Arun District Council
1 Maltravers Road
Littlehampton
West Sussex
BN17 5LF

Applicant: Bellway Homes Limited
Site: Land East of Wandleys Lane, Fontwell, West Sussex
Proposal: Approval of Reserved Matters following the grant of outline planning permission WA/35/23/OUT, for the construction of 95 new homes, access, new pedestrian and cycle links, open space, landscaping, habitat creation, drainage features and associated groundworks and infrastructure, including details relating to the sensitive lighting strategy, POS details and Part M Compliance Details.

Drawing Title
DRAINAGE STRATEGY
SHEET 1 OF 2

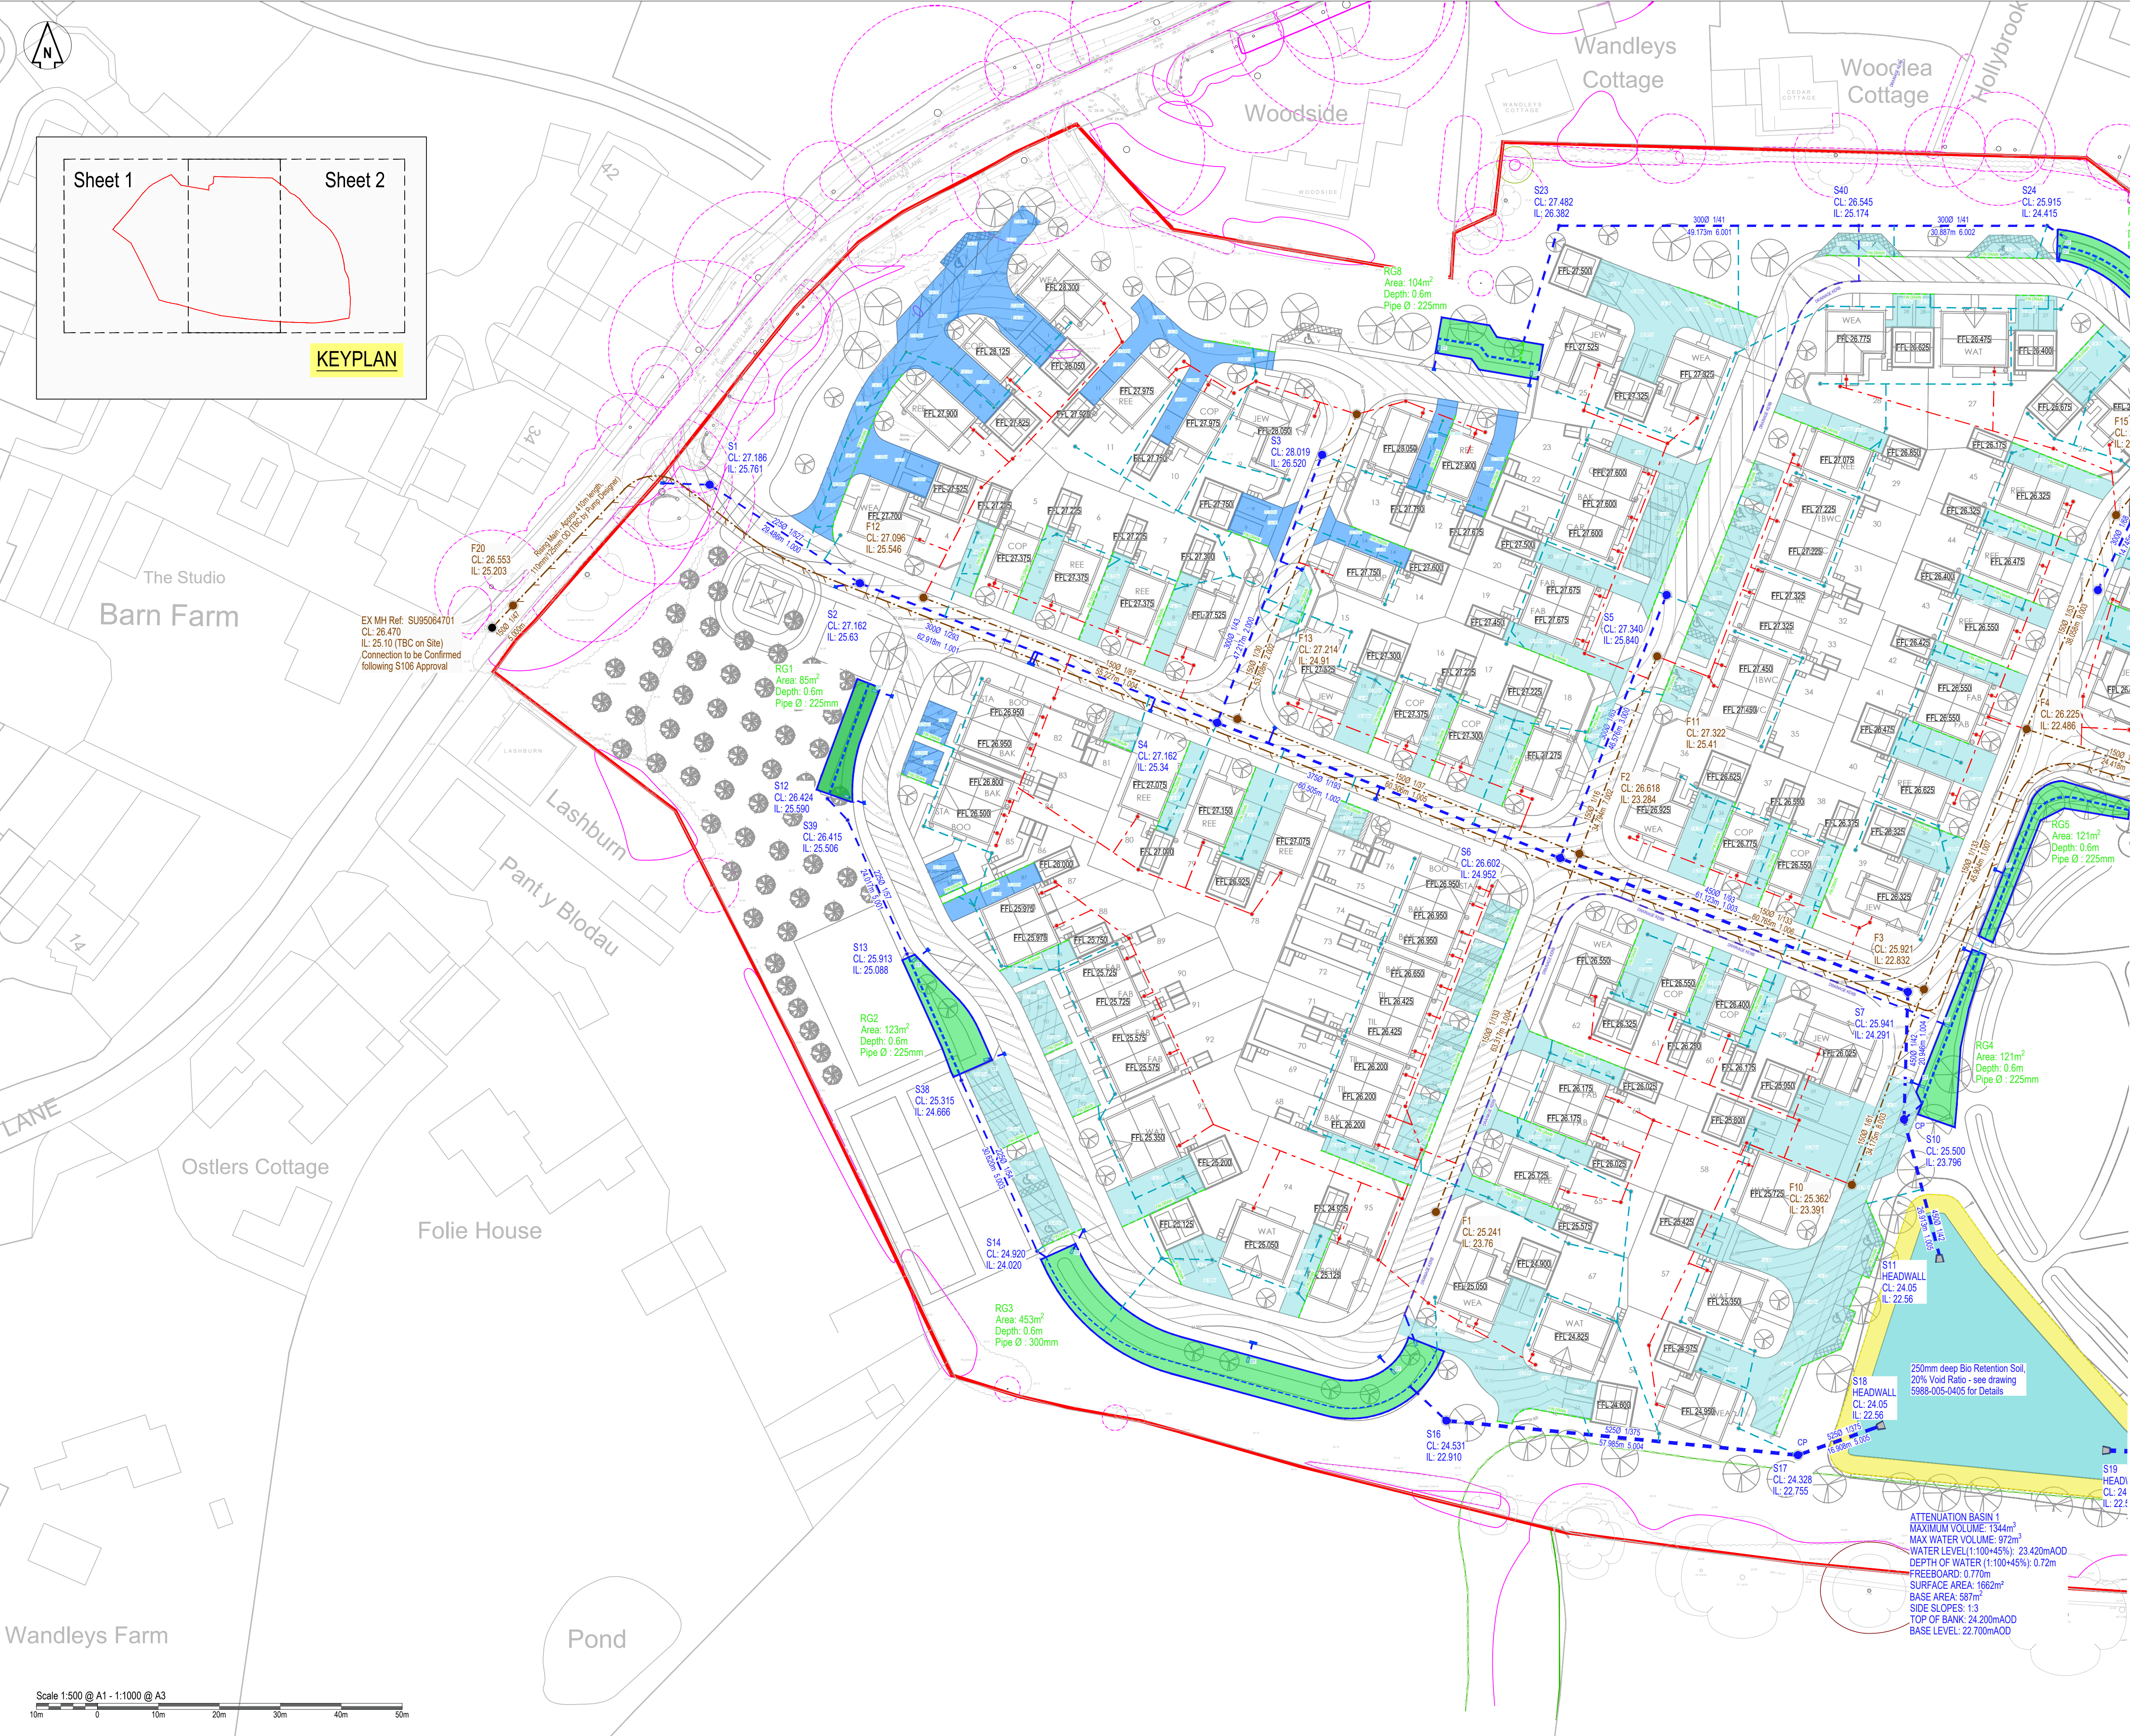
- Discrepancies between the drainage layout drawings and hydraulic modelling calculations relating to flow control details, basin invert levels and storage volumes.
- Incorrect climate change allowance references which were not site specific.
- Lack of consideration of rainwater harvesting measures.
- Need for evidence demonstrating connectivity of the receiving watercourse to the wider drainage network.
- Requirement for further information regarding the outfall arrangement and potential surcharging.
- Additional interception calculations and tabulated evidence to demonstrate compliance with drainage standards.

- Updating drawings and calculations to resolve identified discrepancies.
- Revising climate change calculations to ensure consistency and site-specific assessment.
- Proposing water butts on all residential plots as a rainwater harvesting measure.
- Providing watercourse mapping demonstrating connectivity to the wider network.
- Updating calculations to include a surcharged outfall and providing additional survey information of the receiving ditch. An inset panel has been added to the drainage drawing to better show the survey of the ditch that is being connected to.
- Revising the interception assessment table in accordance with LLFA requirements.

Drawing Title
DRAINAGE STRATEGY
SHEET 2 OF 2

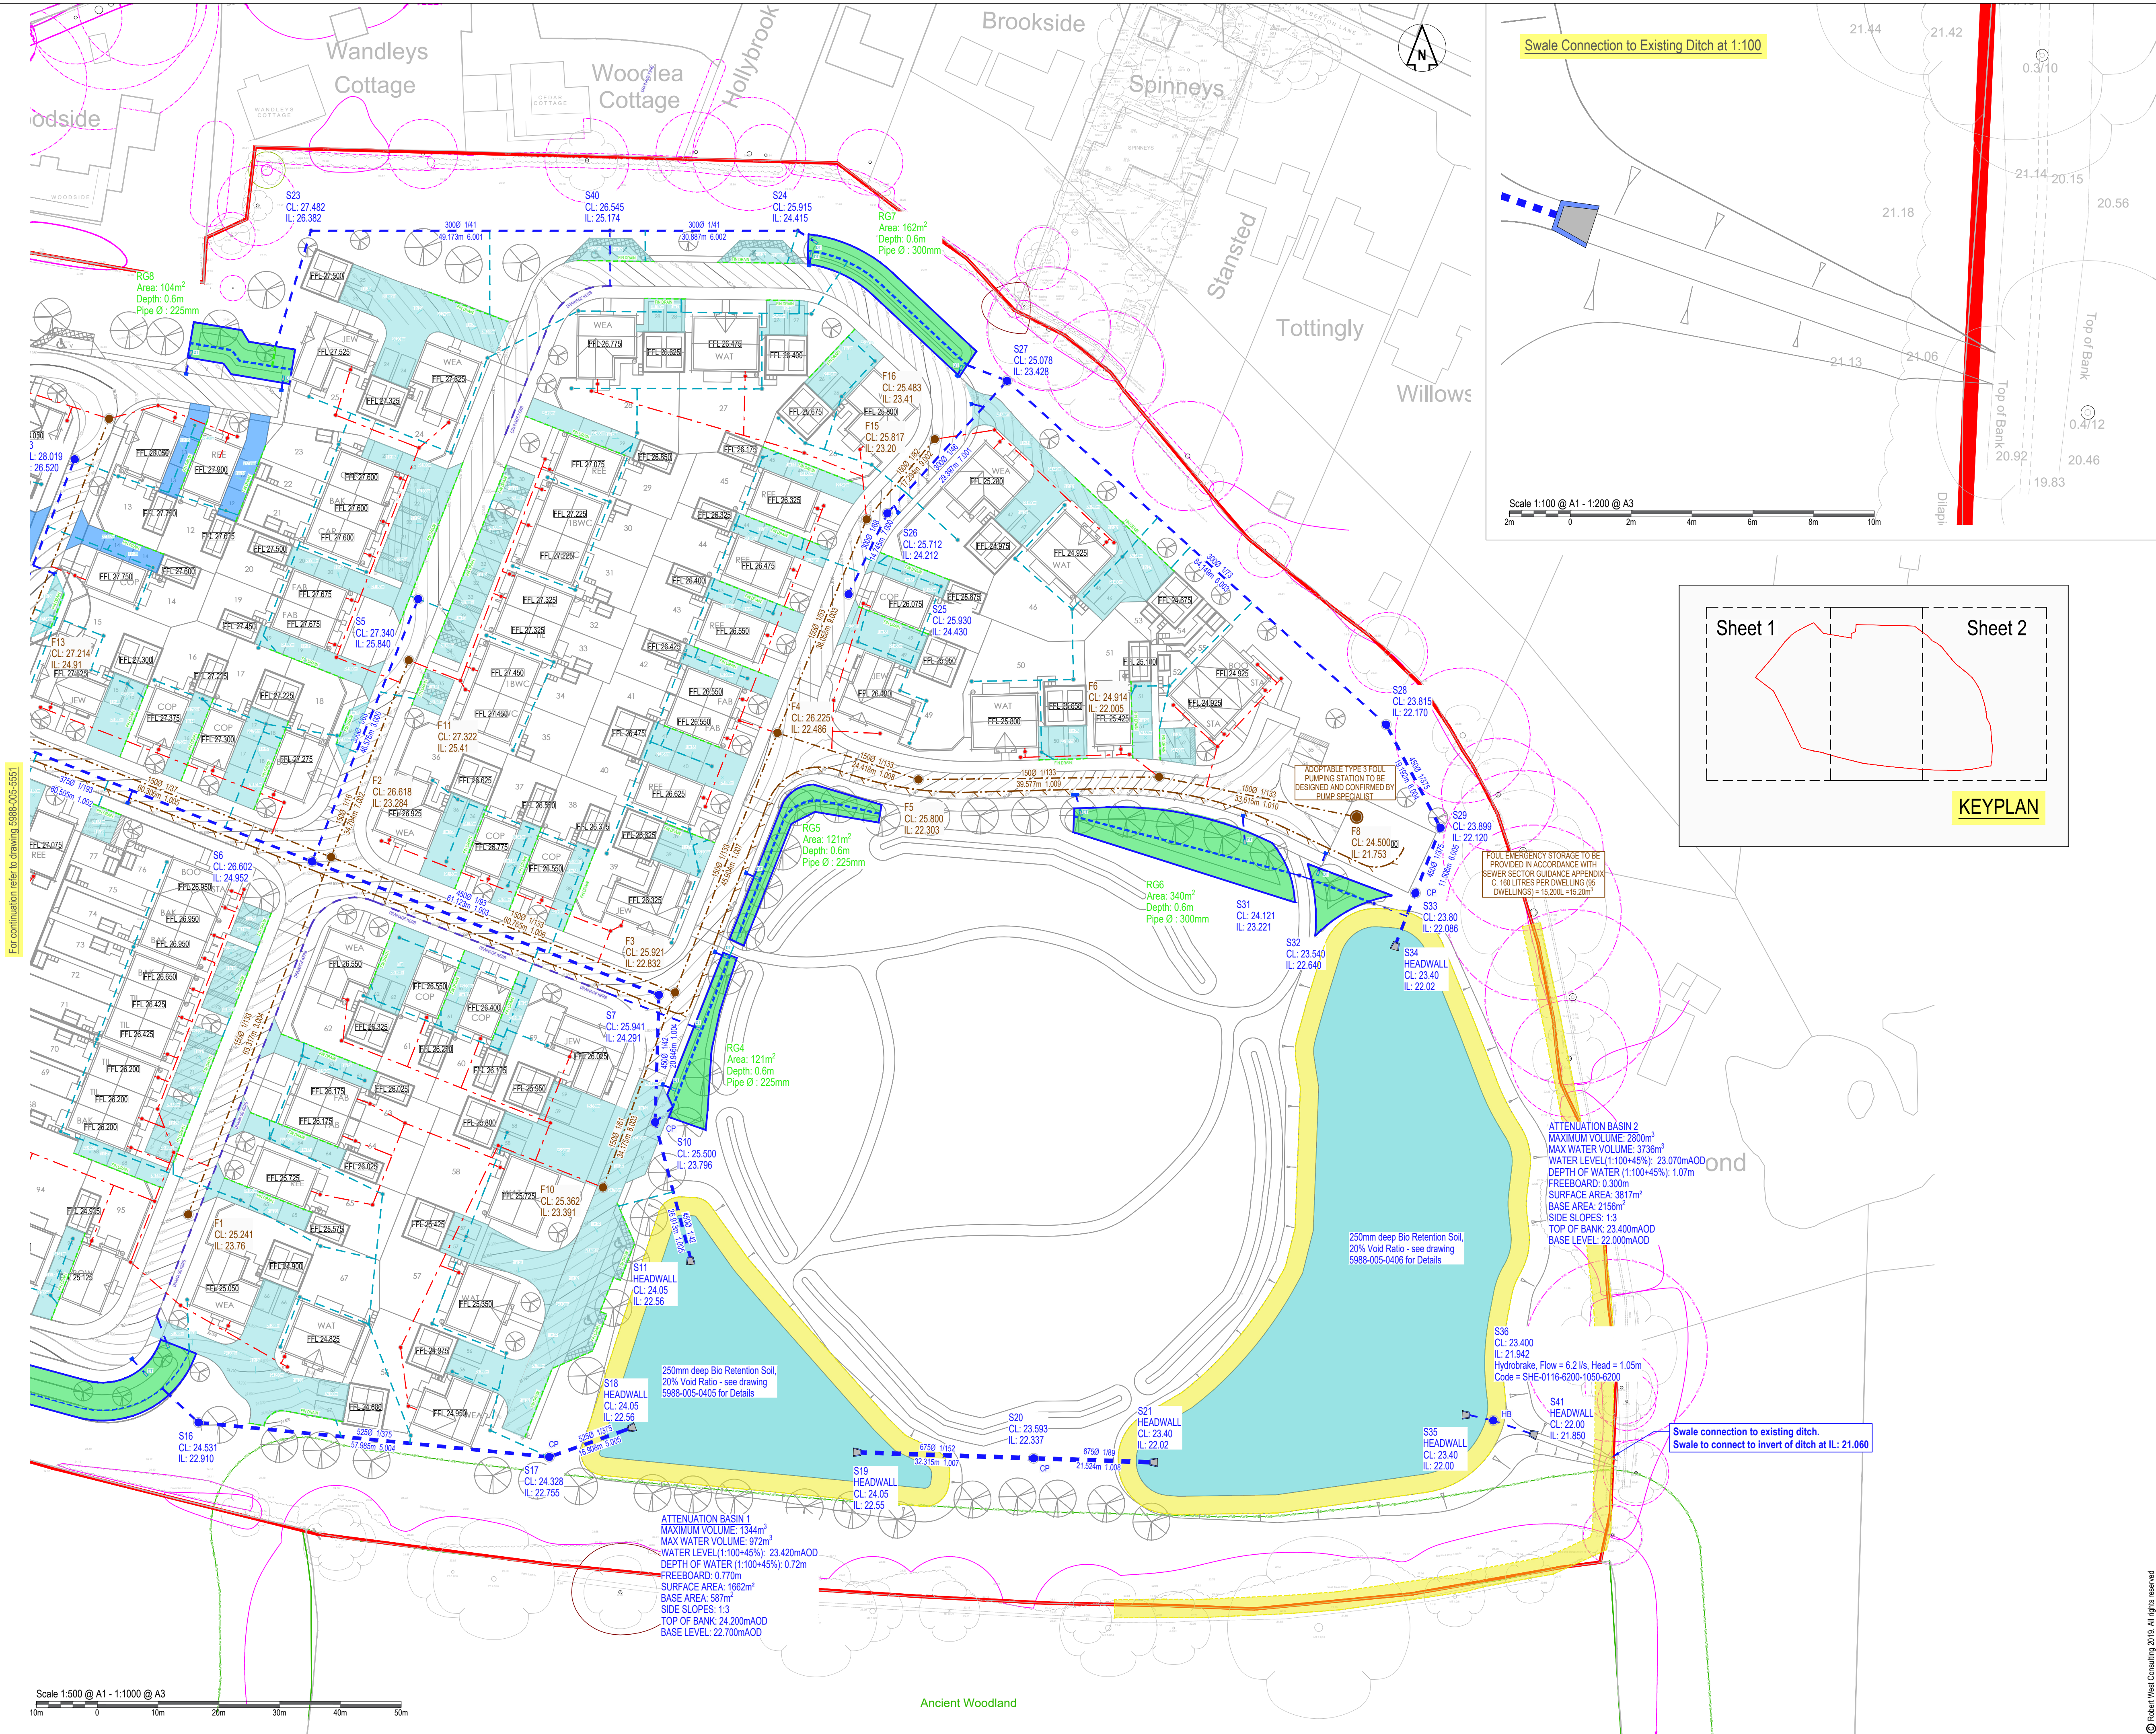
In correspondence with P.Cann, of Arun District Council, earlier this year, it was concluded that responsibility for the watercourse lies with the landowner/s in who's land it is located. If any part of the

watercourse is located in land not owned, then 50/50 riparian responsibility will apply (ie. landowners either side). The proposal is in line with the above.

Our proposal allows for a swale connection on our riparian side of the watercourse. As no structure is proposed and has no encroachment to the watercourse, then only land drainage byelaw consent will be required from Arun, of which an application can be submitted as the site progresses to commencement. We achieve as much freeboard as possible between the outfall pipe invert and existing ditch bed (we comply with the minimum 150mm).
